1 Technical Note – Environmental Health Consultation Response

- 1.1 Arun District Council are currently determining a planning application (A/39/21?DOC) seeking the discharge of Condition 9 of the outline planning permission granted for a new residential development on Land South of Water Lane, Angmering (outline permission ref. A/99/17/OUT).

- 1.2 The application to discharge the condition was accompanied by a “*Sound Insulation Assessment*” prepared by Mayer Brown Limited.
- 1.3 The report has been reviewed by the District Council’s Environmental Health Team who have made a number of comments (as set out in the EH Team’s email response to the planning case officer on 16th April 2021).

Calculation Sheet		13	Receiver	Plot 72 - Gnd Floor	
Room Type	Façade Dimensions		Window Dimensions	Room Area	Volume
	W (m)	H (m)	Areas (m ²)	m ²	m ³
Living Room	4.00	2.60	2.30	17.2	44.7

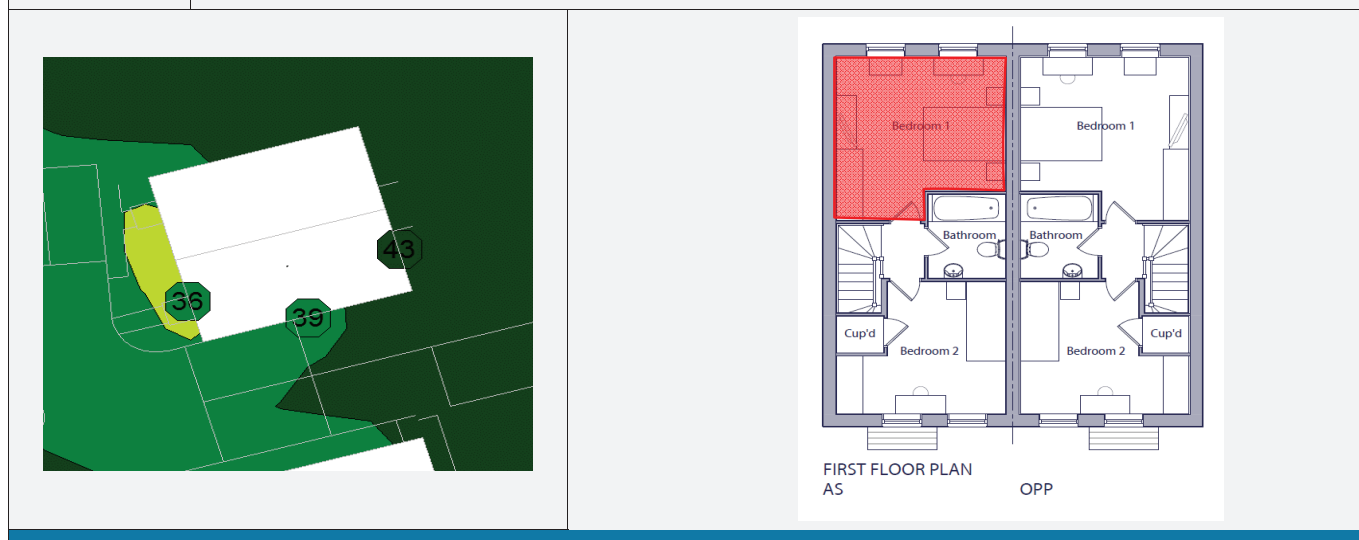
** Plot 72 – Will this drawing will be reversed so that the longest façade, including bedrooms, will face the A280”*

- Flats 160 – 167 – Block plan updated. The block is only 2 storey;
- Flats 168 – 169 and 170 – 173 have been included;
- Flats 174 – 175 - House type plan has been re-orientated relative to the A280; and
- Plot 72 – House type plan has been reversed relative to A280.

Calculation Sheet		24	Receiver	Plot 160-167 - 1st Floor	
Room Type	Façade Dimensions		Window Dimensions	Room Area	Volume
	W (m)	H (m)	Areas (m ²)	m ²	m ³
Bedroom	3.30	2.50	1.50	14.30	35.75

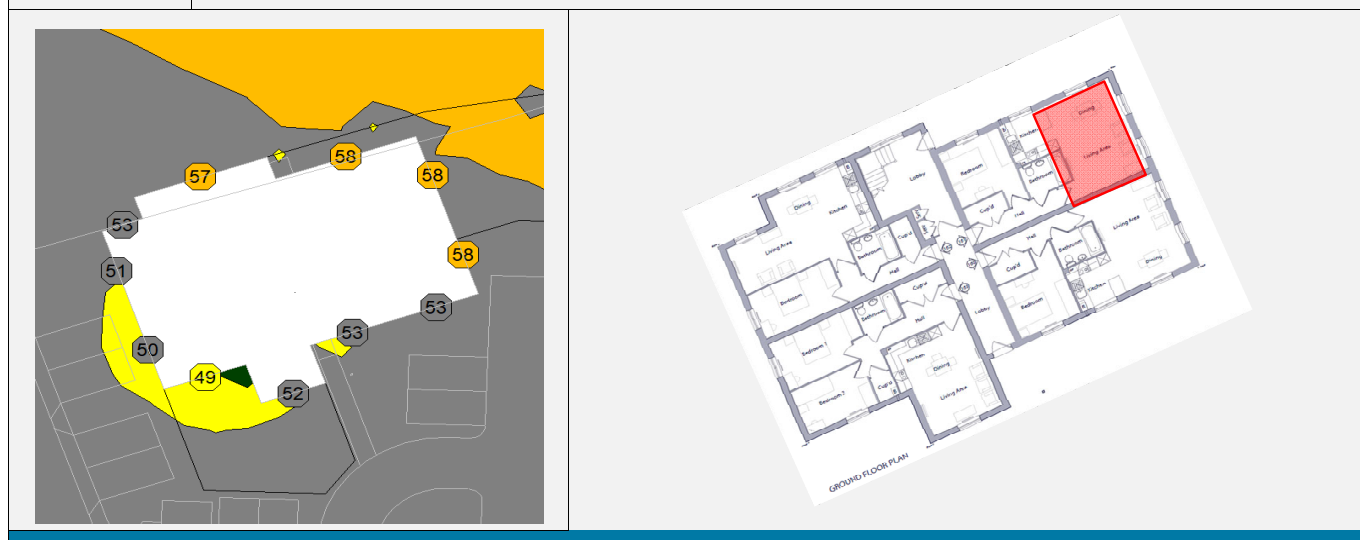
**the outline of the 8 flats, 159 to 167 (actually 160 – 167) does not accord with the outline of the room layout plan. The second floor (not described) is presumed to have the same noise exposure as the first floor.*

Calculation Sheet	28	Receiver	Plot 170 -173 - Bedroom		
Room Type	Façade Dimensions		Window Dimensions	Room Area	Volume
	W (m)	H (m)	Areas (m ²)	m ²	m ³
Bedroom	4.20	2.50	2.20	14.20	35.50

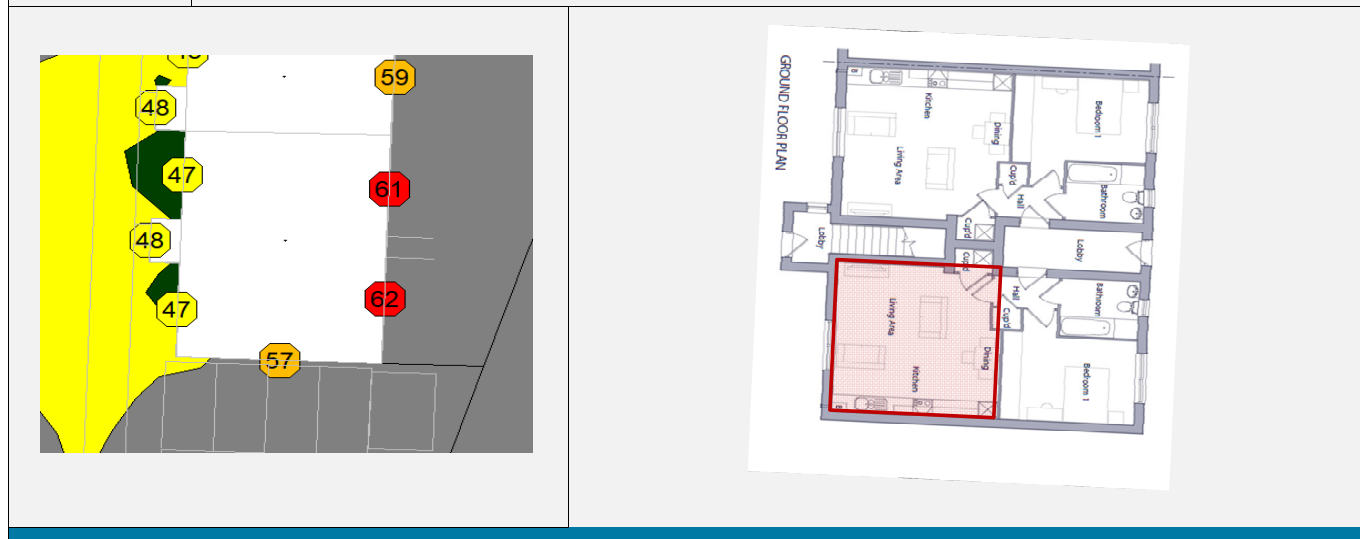
** Flats 168-169 and 170 – 173 should be included in this Appendix at least in that the orientation of habitable rooms should be described*

Calculation Sheet	29	Receiver	Plot 174 - Gnd Floor		
Room Type	Façade Dimensions		Window Dimensions	Room Area	Volume
	W (m)	H (m)	Areas (m ²)	m ²	m ³
Kitchen/Dining	4.00	2.60	1.20	18.7	48.6

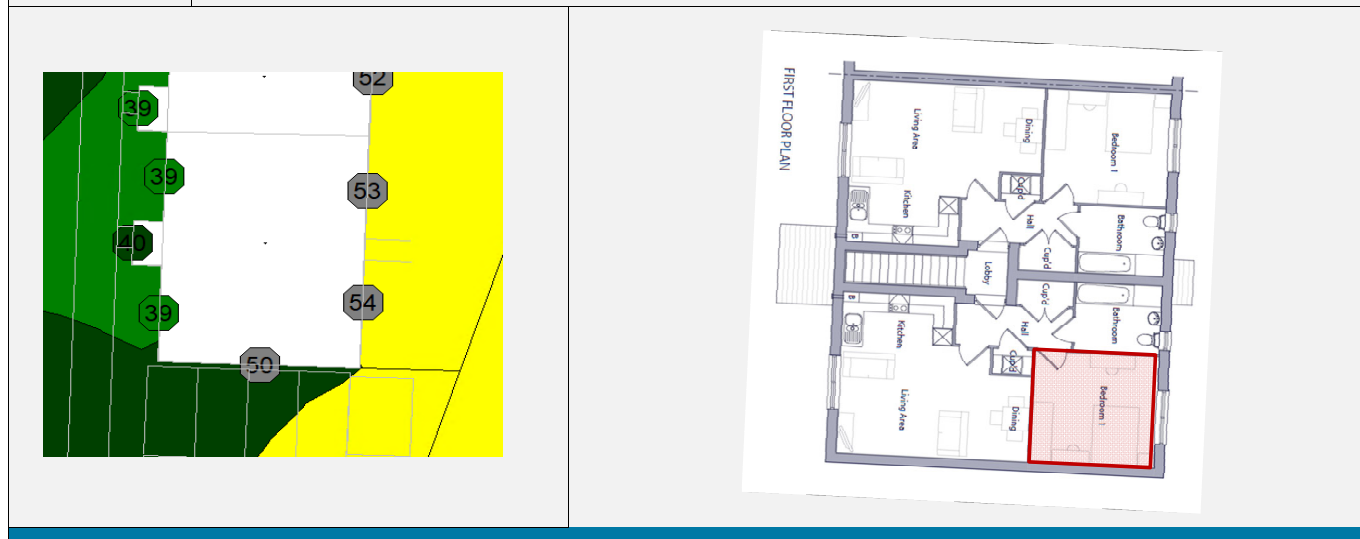
** Flats 174 to 175 – does not show that the longer ‘stairs’ façade will face the A280, in which case bedrooms on the opposite flank would be protected from road noise*
